Application No: P/171/21/DOC
Site Address: Rear of Inglenook Hotel 253-255 Pagham Road Pagham PO21 3QB
Description of works: Approval of details reserved by condition imposed under ref W/4001476 (P/58/19/PL) relating to Condition Nos 10 - proposed location of one fire hydrant or stored water supply, 12 - soft & hard landscaping, 14 - materials & finishes and 15 - boundary treatments.

Thank you for your internet representation made on 15th January 2022 which has been recorded as an objection with the comments as follows:

INGLENOOK PROPOSED FIRE MAIN SKETCH

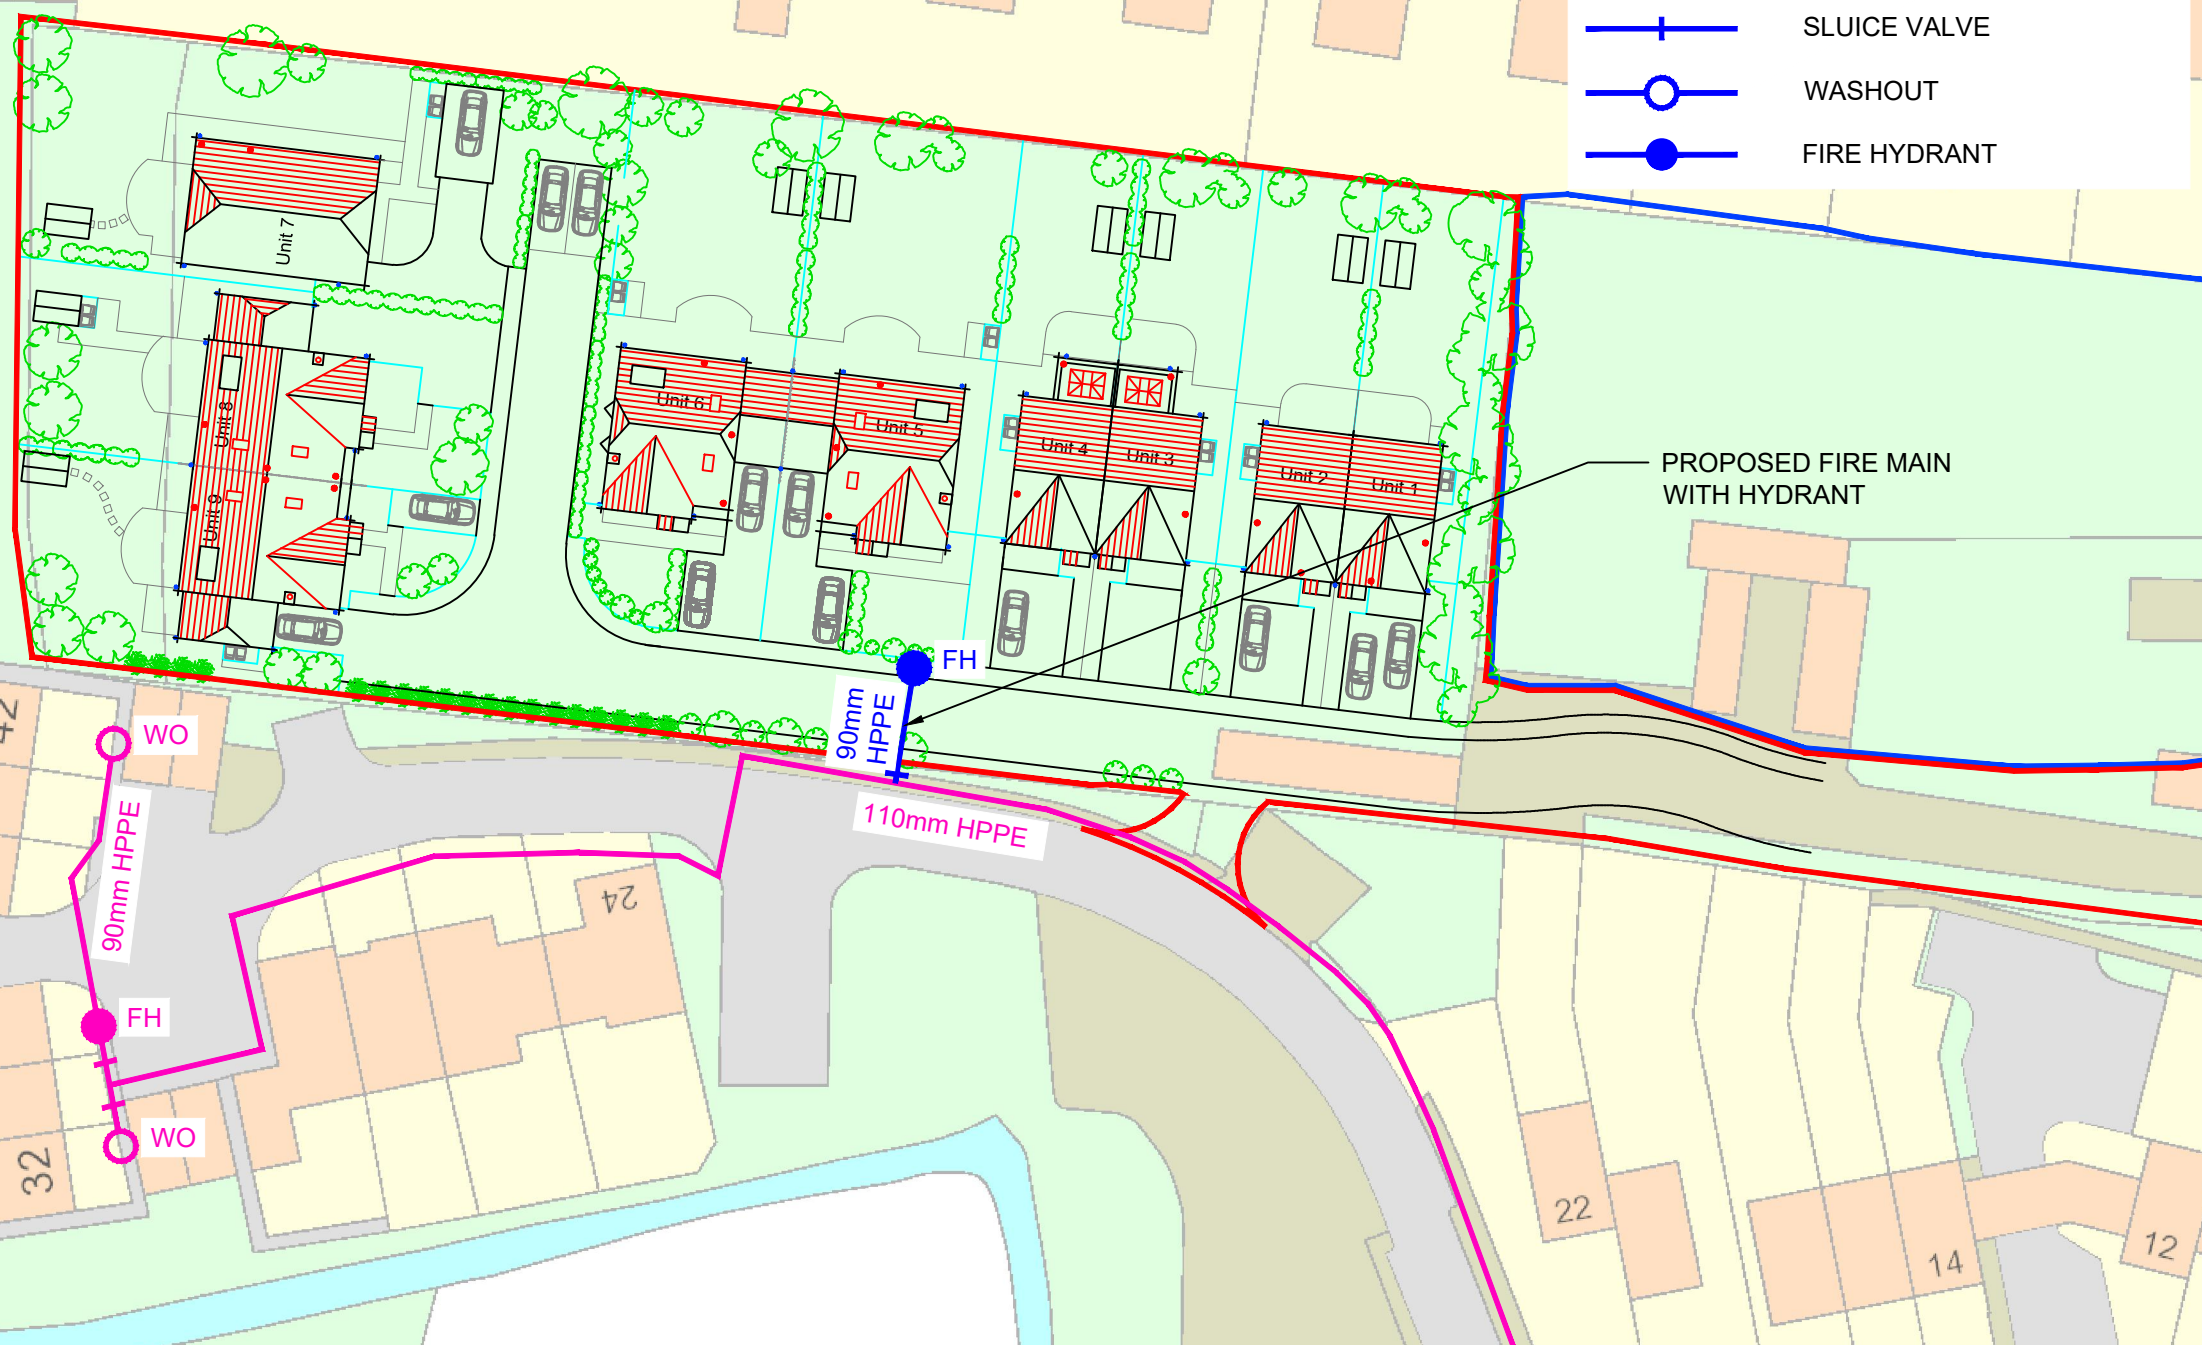
I strongly object to the planning application for the following reasons

- 1 The Inglenook Hotel has an excellent high pressure water supply.
- 2 it also Must have a supply of water because the builders use it.
- 3 To brake into spinnaker view supply has no benefit at all except to save the builder money
